**KIRKLEES METROPOLITAN COUNCIL
INVESTMENT & REGENERATION SERVICE**

DELEGATED DECISION TO DETERMINE PLANNING APPLICATIONS

Reference No:	2022/62/91270/W
Site Address:	9, Lumb Lane, Almondbury, Huddersfield, HD4 6SZ
Description:	Replacement of balcony to rear of bungalow
Recommending Officer:	Ellie Worth

DECISION – Conditional Full Approval

PROPOSED SIDE ELEVATION (W)

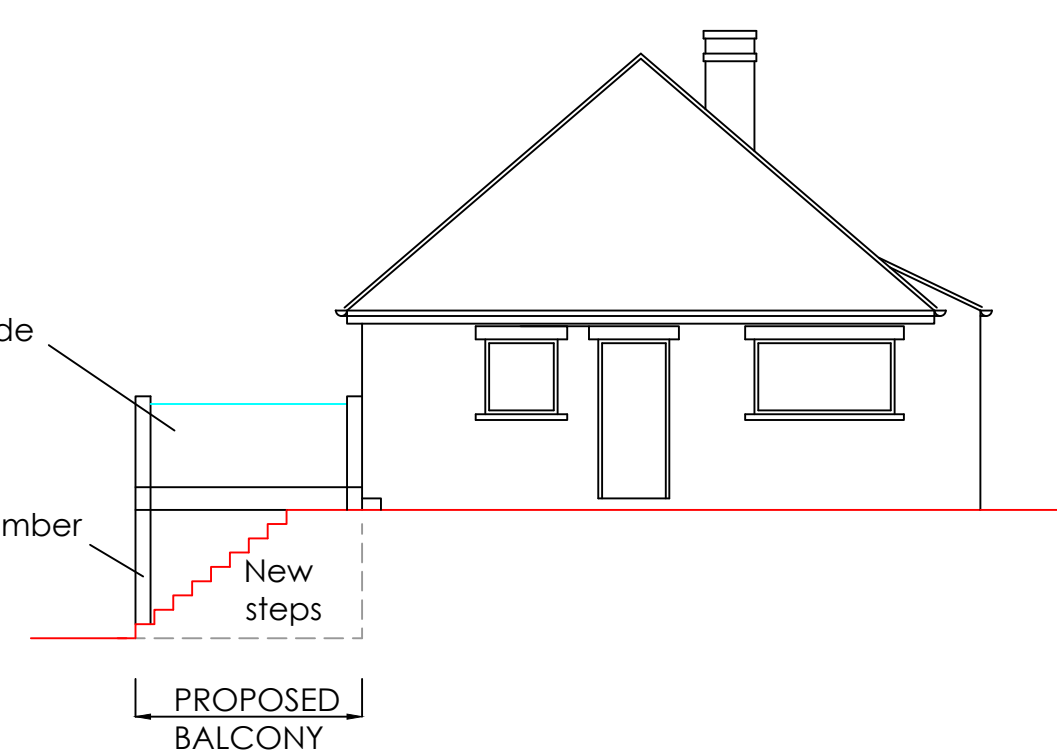
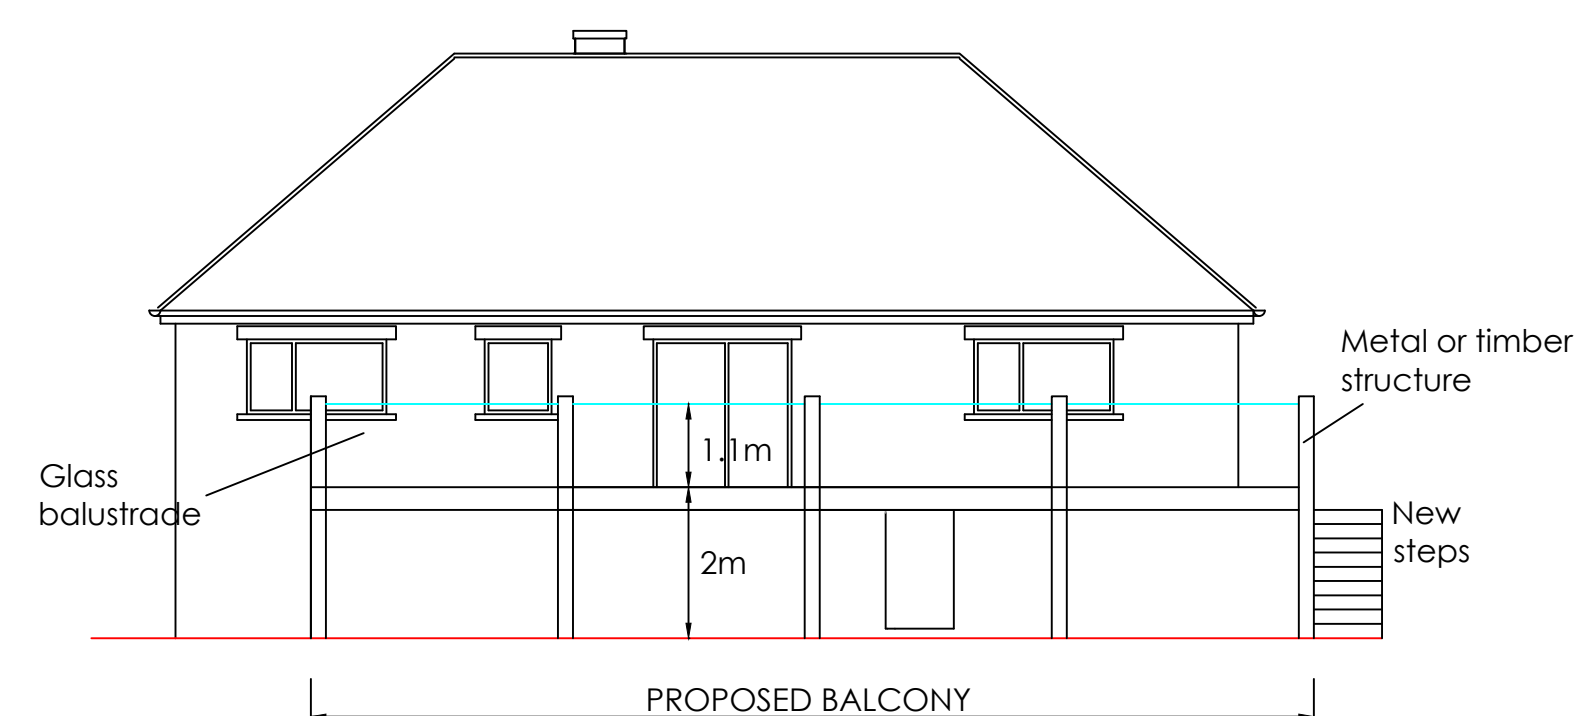
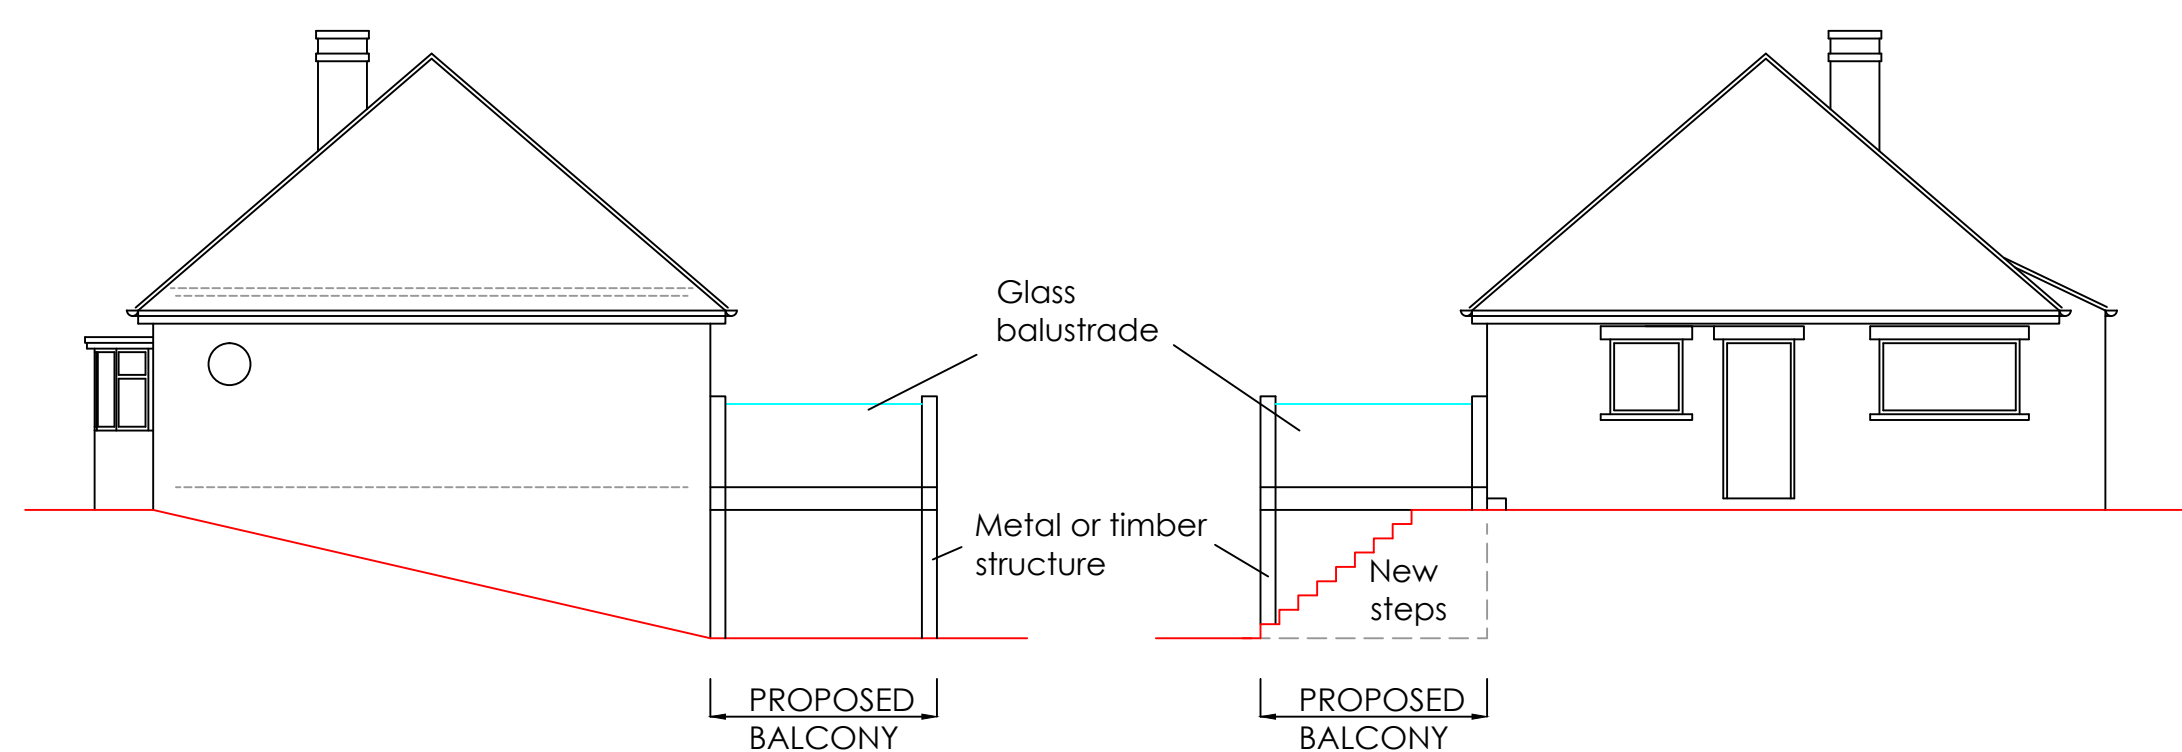
7 Lumb Lane is the neighbouring property to the East of the application site. It has been noted that the balcony would extend close to the side boundary shared with No.7. However, No. 7 appears to be set further back into its plot, with no existing side openings facing the site, and the balcony would not protrude far beyond the rear wall of neighbouring dwelling at No.7. As such, there are considered to be no significant overbearing or overshadowing impacts from the works proposed including the glass balustrade.

Nonetheless, it has been noted that these neighbours benefit from a rear balcony and whilst it may be at an oblique angle to the host property, there is potential for adverse overlooking especially given the close proximity of the

proposed balcony to this neighbouring property. As such, officers consider it necessary to attach a condition stating that the side balustrade should be at a height of 1.8m-2m and fit with obscure glazing. This has been considered necessary in line with Policy LP24 of the KLP and Principle 3 of the SPD. Officers consider that it would be preferable for the proposed balcony to be set further off the side boundary to reduce the amount of overlooking into the rear garden of No.7, but hold the view that the privacy screen would be sufficient to prevent undue harm to No.7. It should be noted that the balcony at No.9 would likely achieve similar views of the rear garden of No.7, as No.7 currently achieves from their balcony of No.9's garden.

Likewise, the impact on No. 11's amenity from the additional built form would be limited, especially due to the balcony not exceeding the full width of the rear elevation (set off 3 metres from the shared boundary). However, whilst the extension would be set-off the shared boundary, it has been noted that these neighbours benefit from a glazed conservatory and a side opening. Therefore, officers consider it necessary to attach a condition to ensure that the side balustrade is fitted with 1.8m-2m high obscure glazing to prevent an undue loss of privacy or overlooking.

3. Notwithstanding the submitted plans, a 1.8m-2m high privacy screen, which shall be blank and exclude any glazing, shall be erected along both side boundaries of the balcony hereby approved. The screen shall be provided before the balcony is first brought into use and shall be retained thereafter.

PROPOSED PLAN

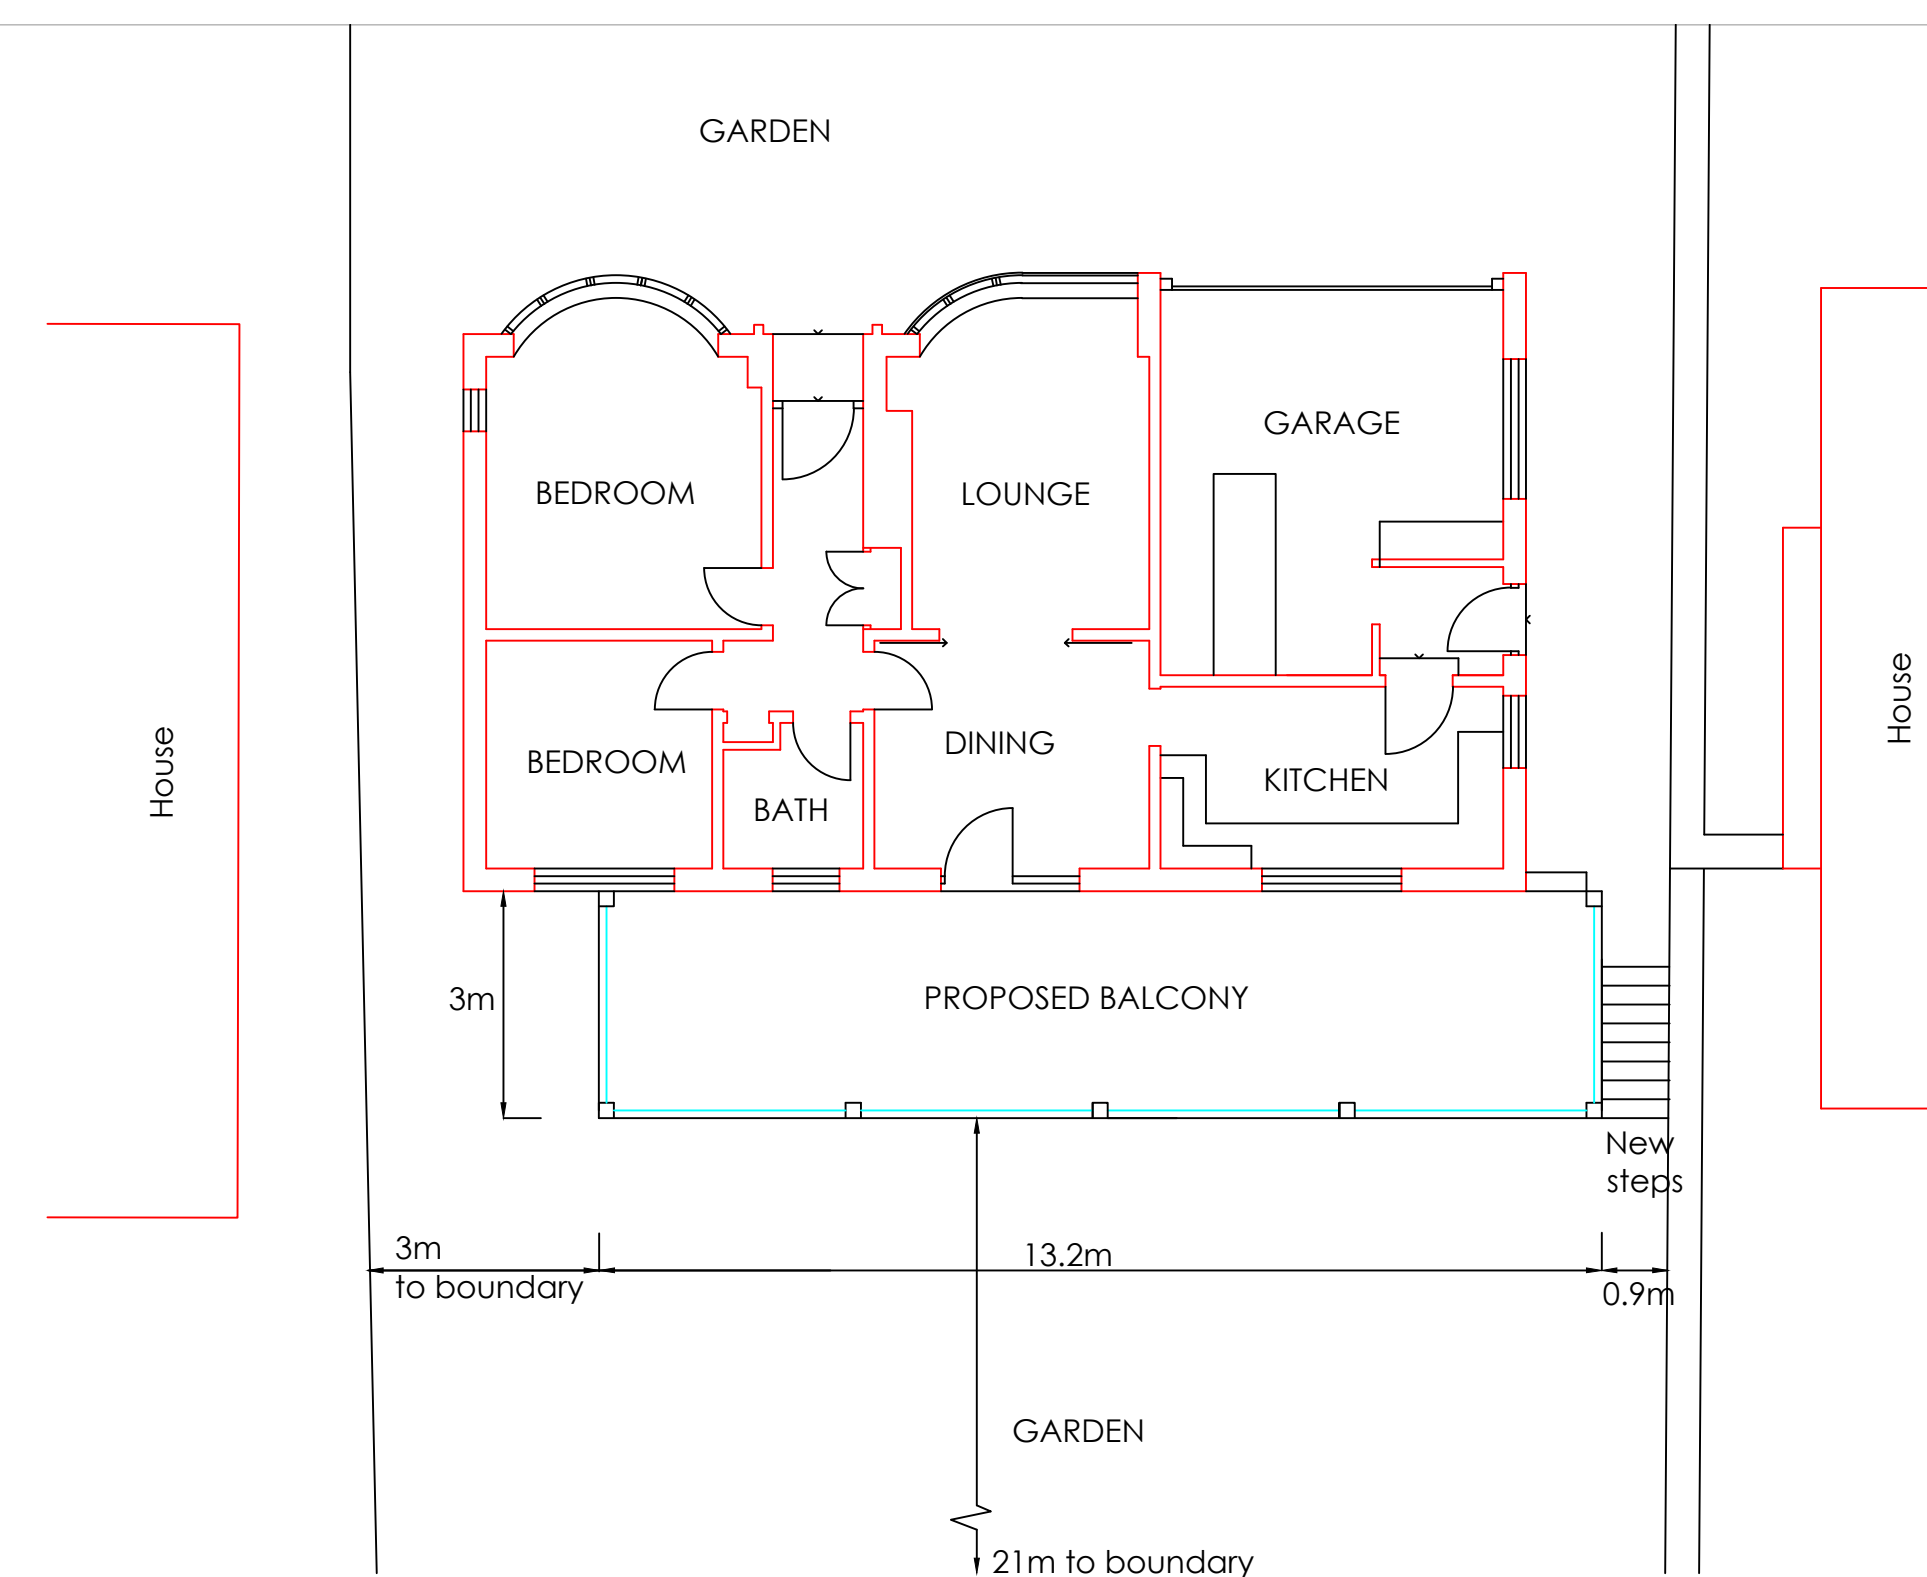
In this case, the applicant is seeking permission for a replacement balcony in which would have a larger footprint than the one in situ. Whilst the built form is not explicitly an extension, additional external floor space would be provided. Therefore, the development has been considered against Policy LP57 (a) of the KLP.

In this instance, the development would result in a 26% increase in floor space to the existing dwelling. When taking this into account along with the open nature of the balcony (i.e. that it would not be covered) and it's relatively low height, it is considered that it would not appear as a disproportionate addition to the existing building.
